Submission to An Coimisiún Pleanála

Proposed Development at San Anton, No. 2 Waltersland Road, Stillorgan

Site Section from No. 56 Merville Road - scale 1:100

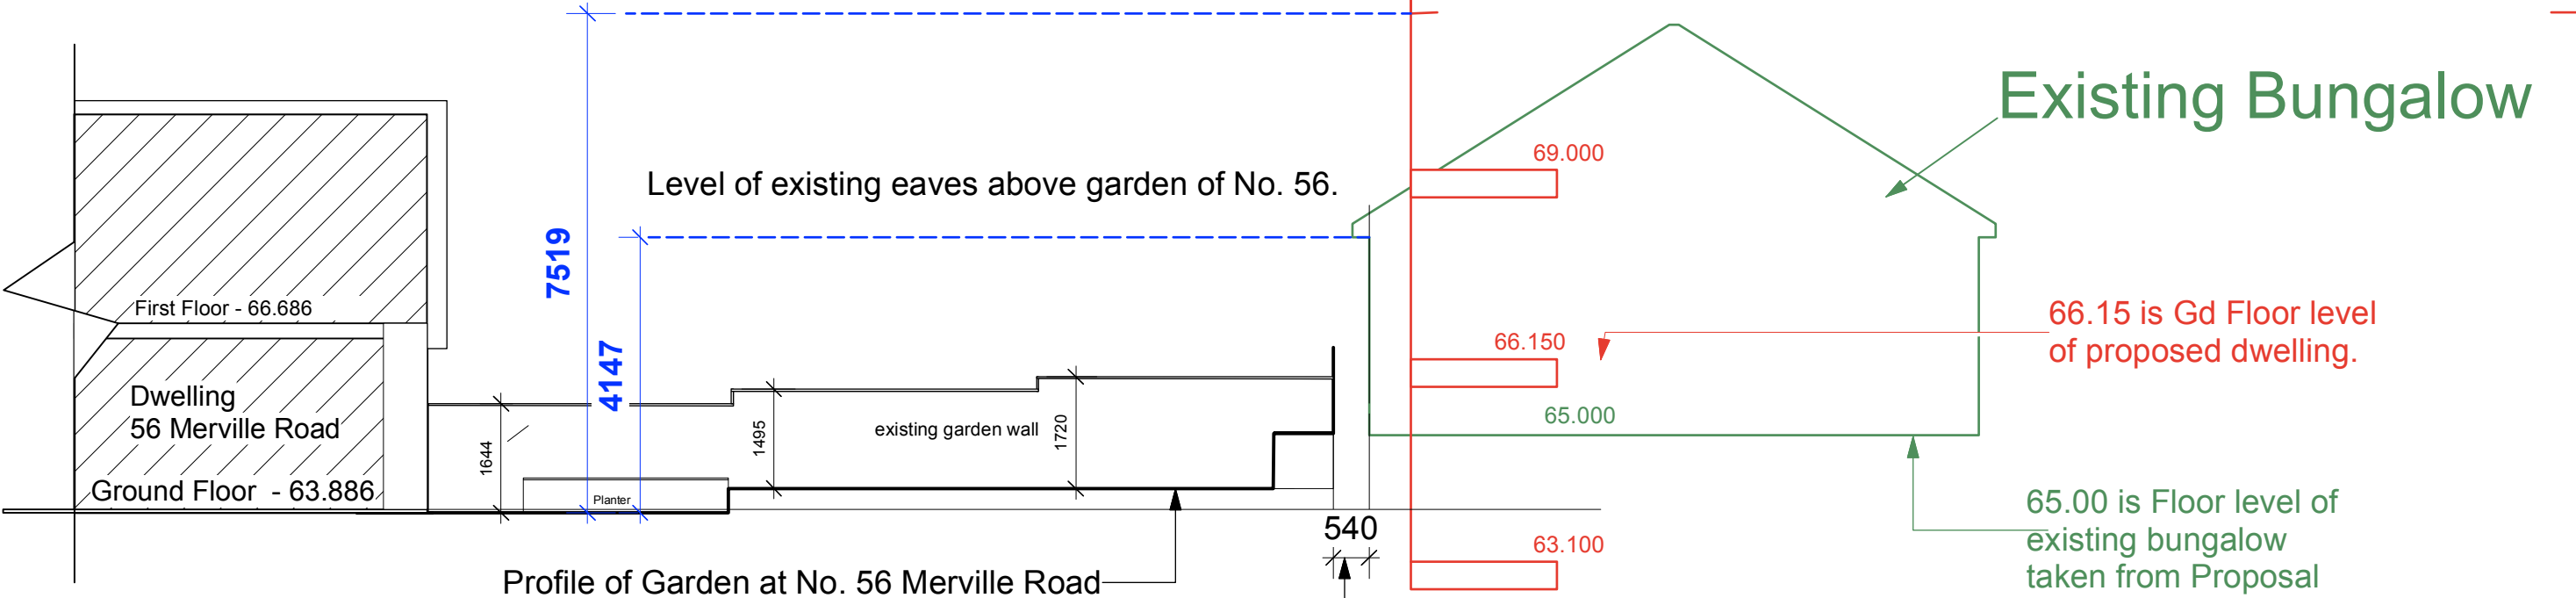
Although described as two-storey over semi-basement, the proposed dwellings present as **three storeys when viewed from the rear and from our property.**

This is particularly significant because of the difference in ground levels between Waltersland Road and Merville Road. The land falls towards Merville Road, with the result that the proposed development would occupy an elevated position relative to our home and garden.

At present, the outlook from our principal living space and garden is towards a single-storey residential backdrop. Under the proposed development this would be replaced by a substantial 3-storey elevated built form, which would be a fundamental change in the relationship between the two sites and materially reduce the existing sense of openness to one of pronounced enclosure.

- reduce the apparent height and massing of the development when viewed from our property;
- achieve a more appropriate transition between the proposed development and the established low-rise properties on Merville Road;
- reduce the sense of enclosure created by the proposed gable elevation facing our garden and

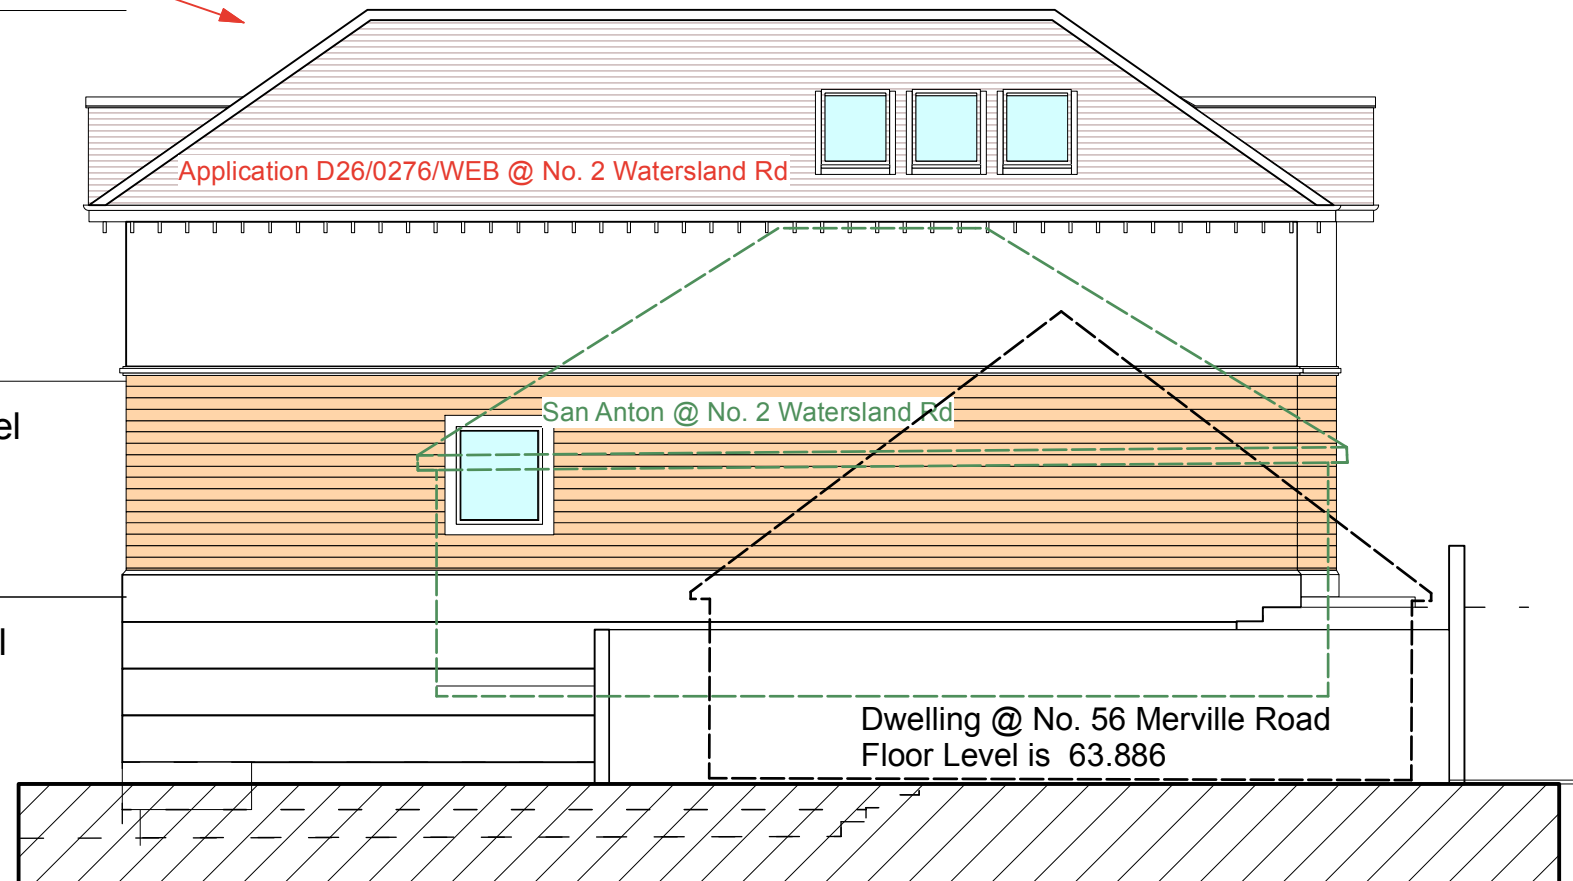
This impact arises irrespective of the detailed treatment of individual windows. Even where direct overlooking can be avoided or mitigated, the physical presence of a substantial three-storey elevation at this location would remain.
